Recommendation Report for Planning Permission for Works or Extension to a Dwelling

REF NO: FG/219/21/HH

LOCATION: 36 Ferring Lane
Ferring
BN12 6QT

PROPOSAL: Proposed re-roofing of existing conservatory and adjustment of existing conservatory fenestrations.

PROJECT
PROPOSED REPLACEMENT
REAR CONSERVATORY ROOF
AT 36, FERRING LANE
FERRING, WEST SUSSEX
CLIENTS
MR & MRS JUSTICE
DRAWING TITLE
PROPOSED ELEVATIONS
DRAWN BY
MR. G. ASKEW MRICS
SCALE
1:100
DRAWING NO.
2021/17/3.
REV

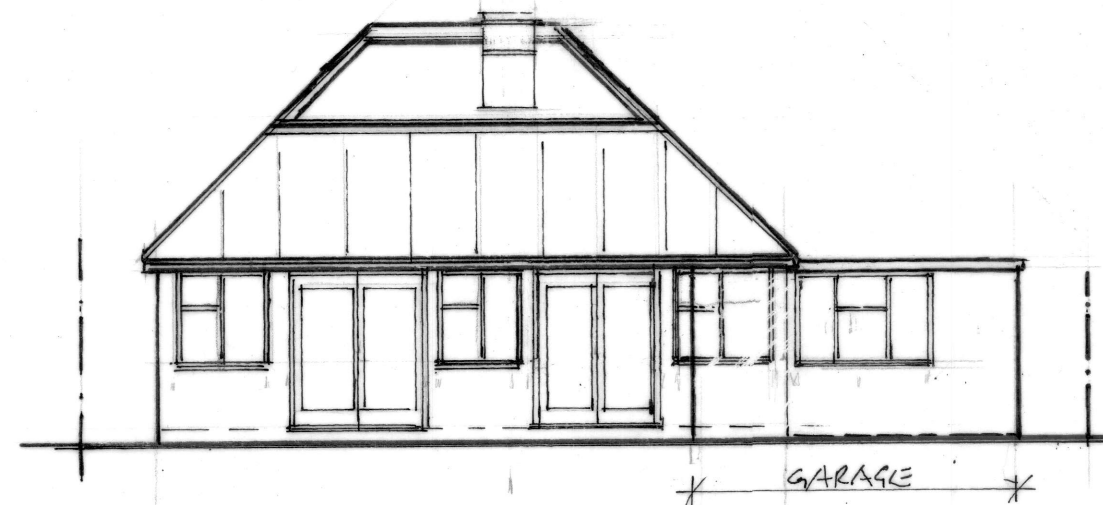
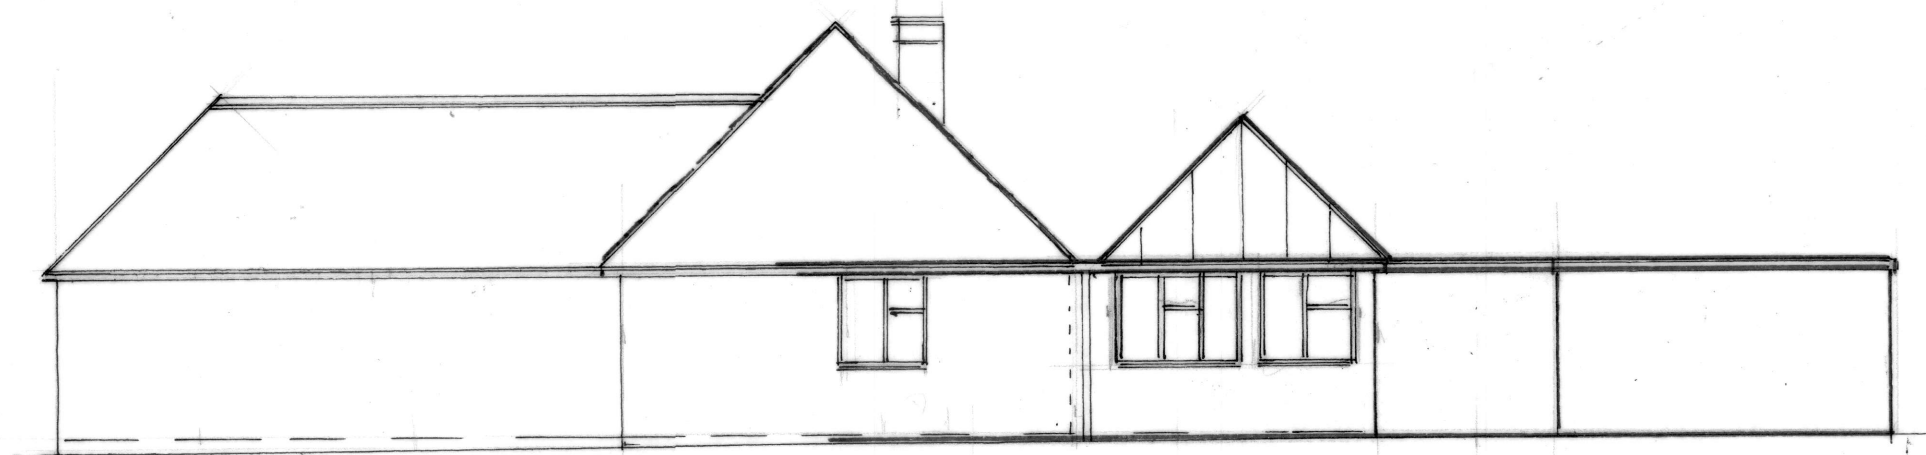
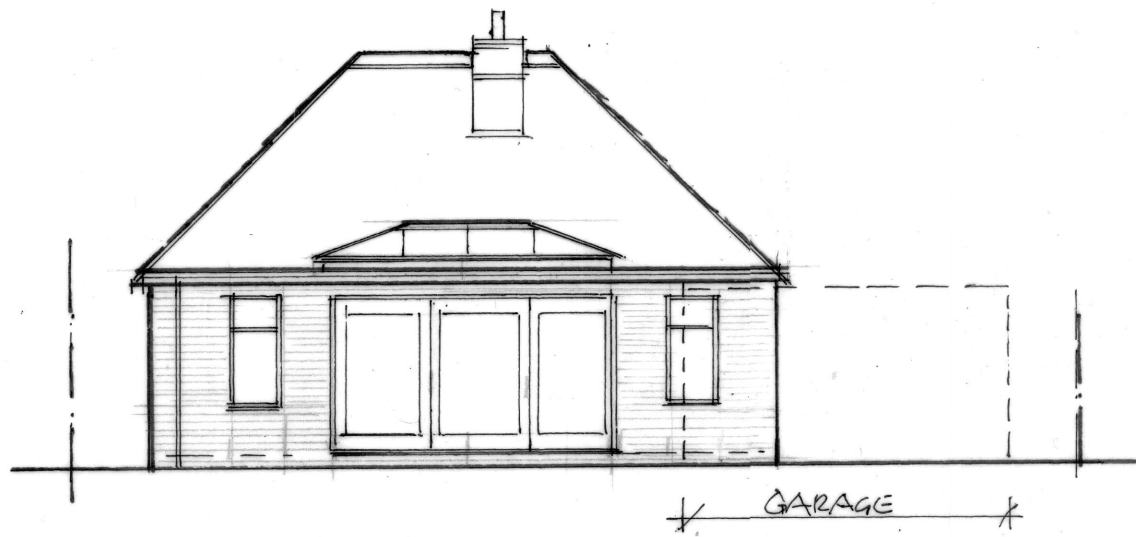
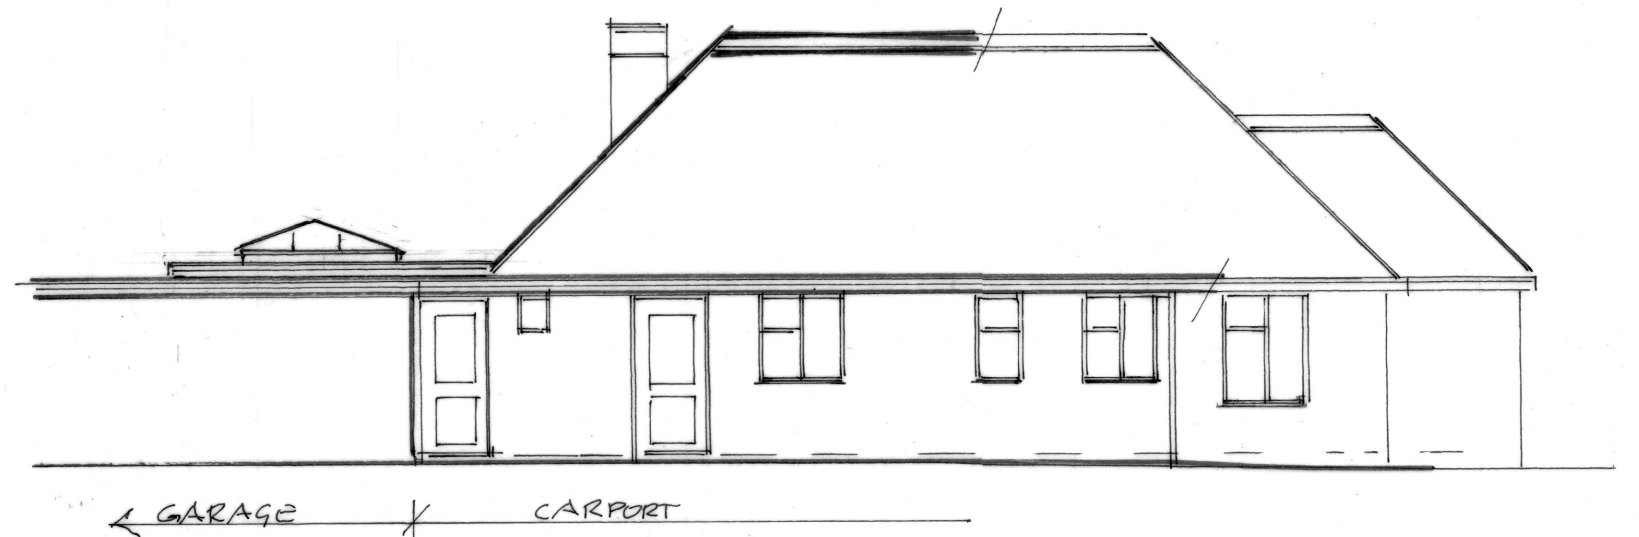
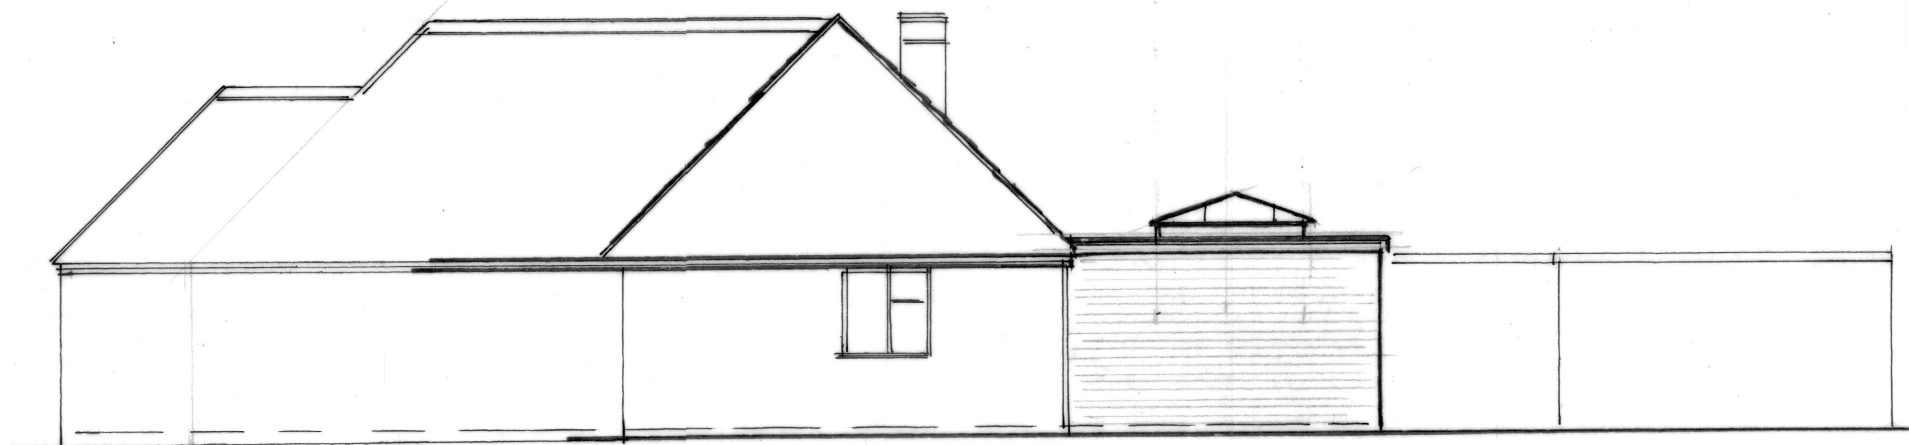
The host dwelling is a large, detached single storey dwelling with an existing rear conservatory that features a glass pitched roof design. The existing conservatory also features windows and glass doors on the southern and western elevations. The proposal seeks to convert the existing roof to a flat roof design featuring a large central rooflight, to remove the western elevation windows and make alterations to the southern elevation windows and doors.

The proposed re-roofing of the conservatory, results in a reduction in peak height from approx. 4.1m to approx. 3.1m. The height of the eaves remains the same. The proposed flat roof design with associated skylight is appropriate and the proposal incorporates matching and complimentary materials to those found on the existing dwelling. This component is a reduction in scale and is visually integrated to the host dwelling.

The removal of the conservatories western elevation windows is appropriate given the conservatories vast access to natural light. The alterations to the southern elevations glass doors and windows are appropriate, complimentary to the conservatories design.
